Application by National Highways for M3 Junction 9 Improvement Scheme
The Examining Authority's 2nd written questions and requests for information (ExQ2)
Issued on 25 August 2023

ExQ2: 25 August 2023**Responses due by Deadline 5: 22 September 2023**

CH-HML-E_M3SB_XX-M2-VFK-ALIGNMENTRH-0001 (CH 2950-3550)
SCALE: Hz 1:1000, Vt 1:200

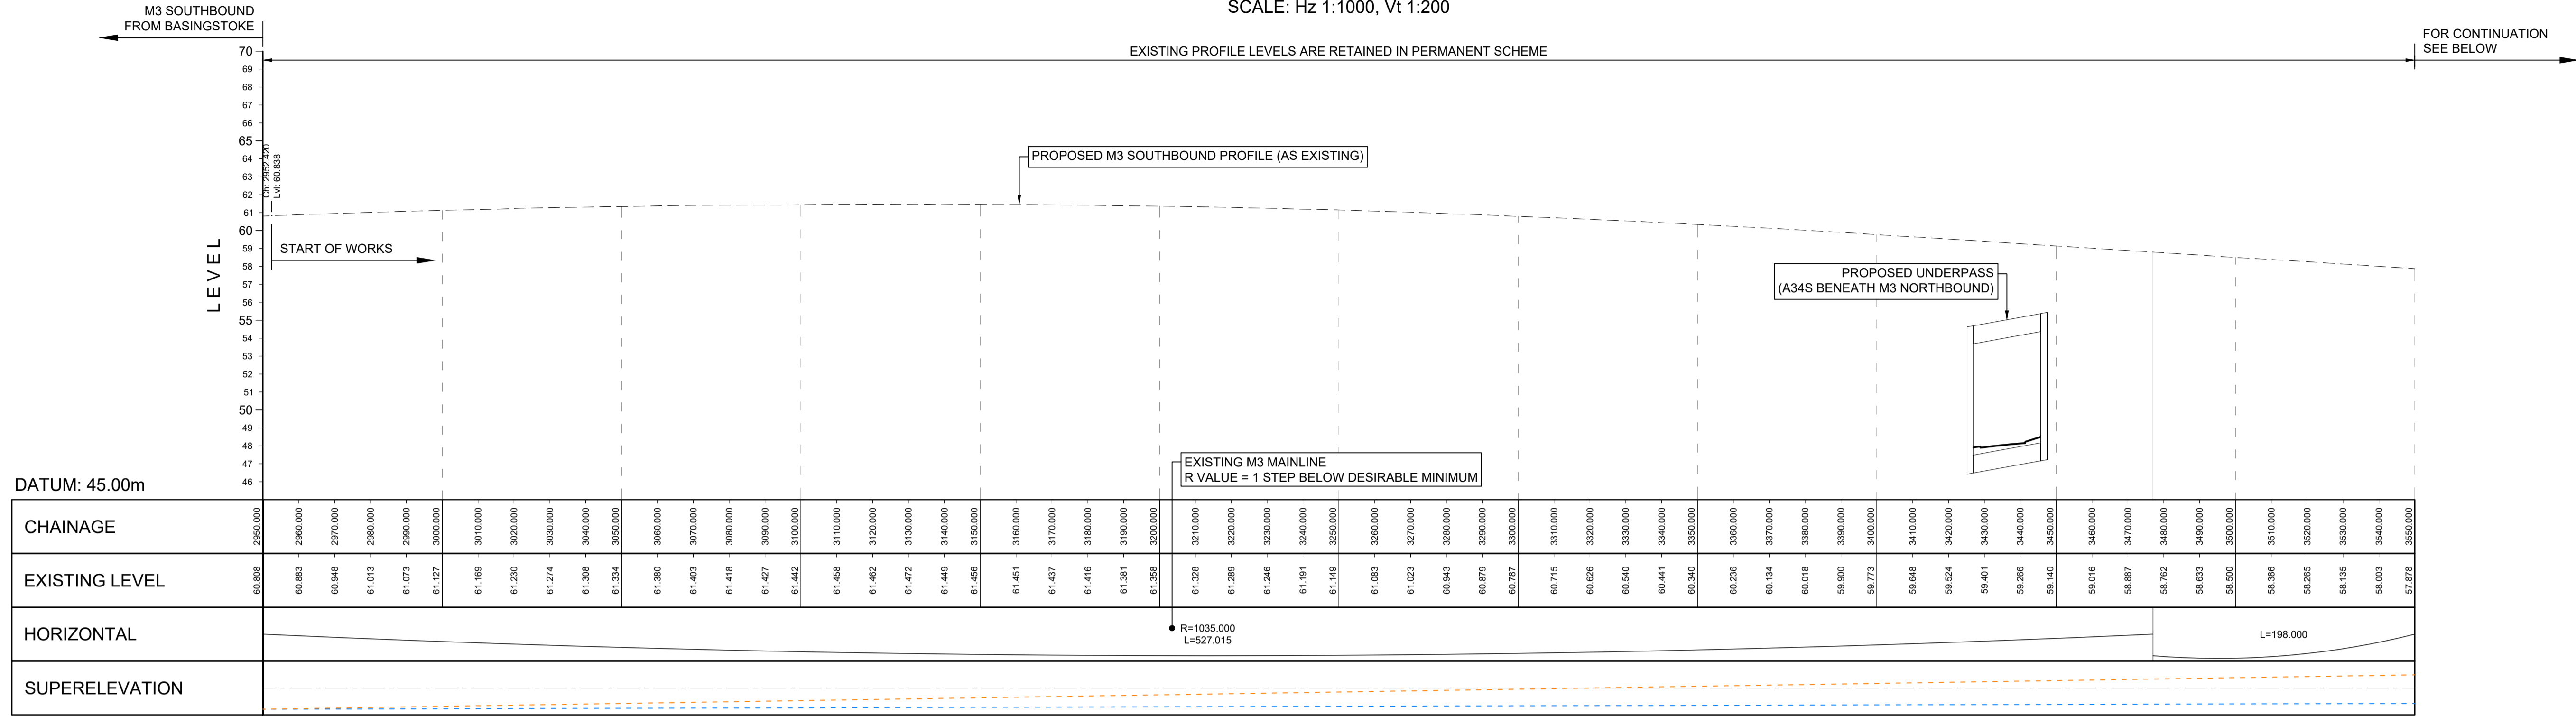
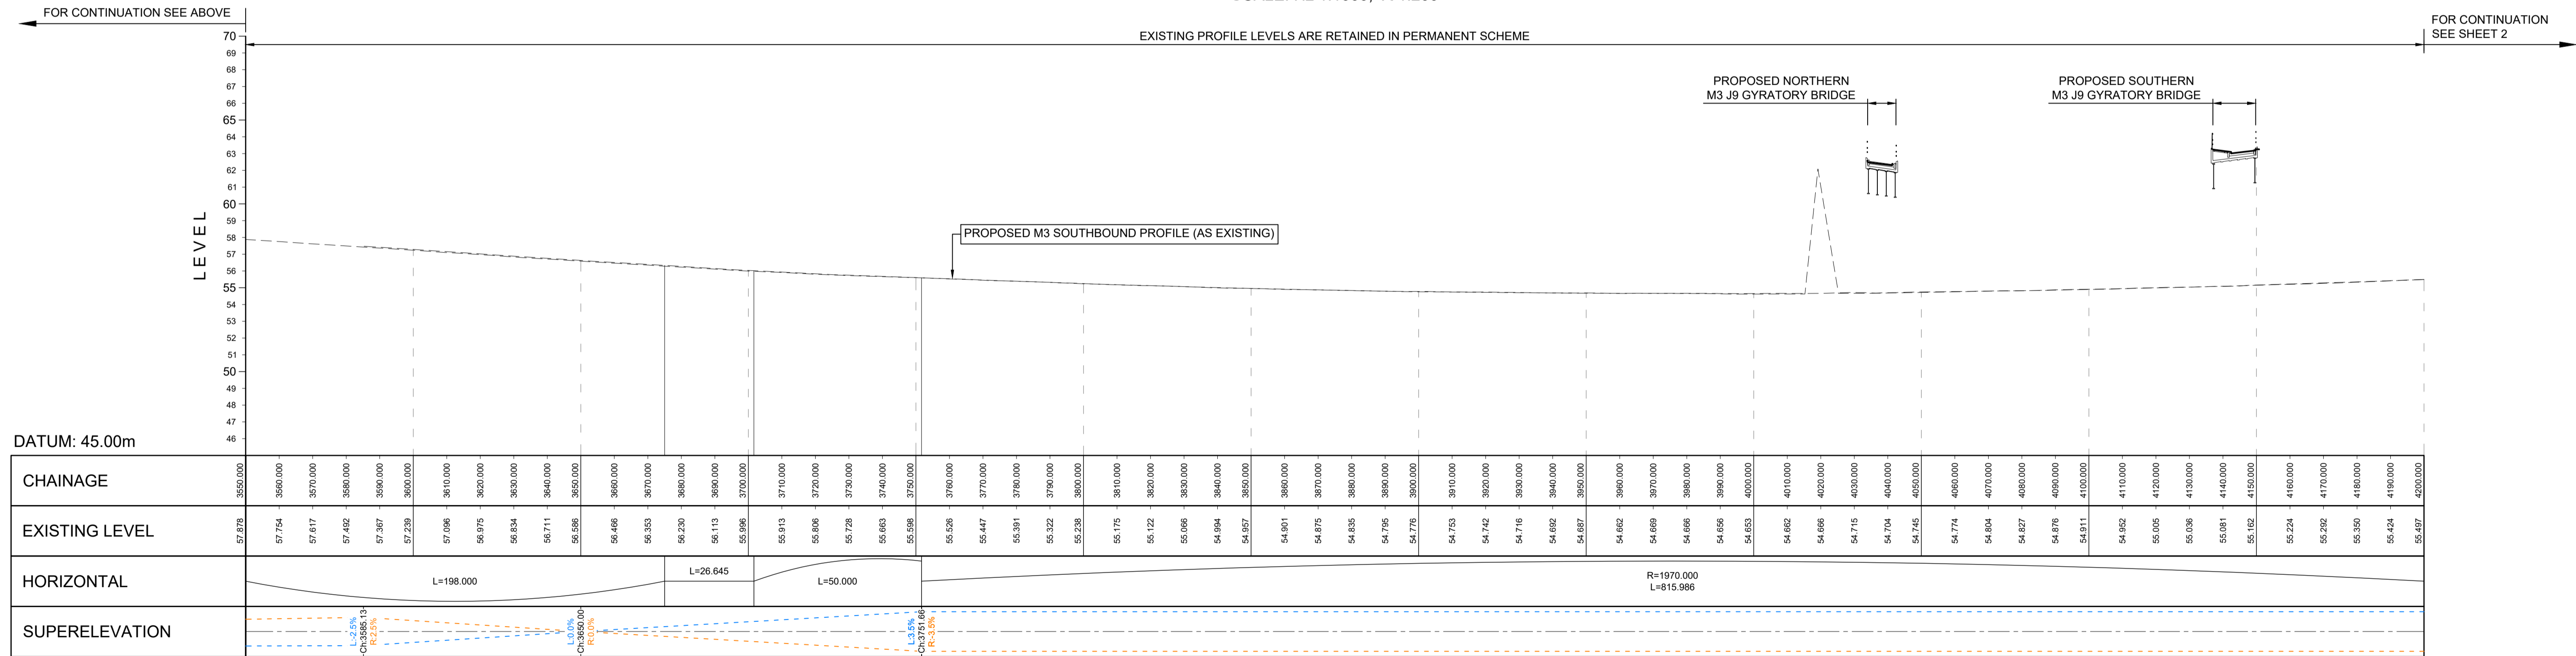
Q1.2.3	General The Applicant	Please provide detailed engineering cross sections at 20m intervals along string CH-HML-E_M3SB between chainages 3000 and 4300. The cross sections should detail the existing and proposed highway and features and also clearly detail the boundary of the SDNP with sufficient distance measurements to allow the ExA to understand the changes to carriageways and highway boundaries as they impact the SDNP.
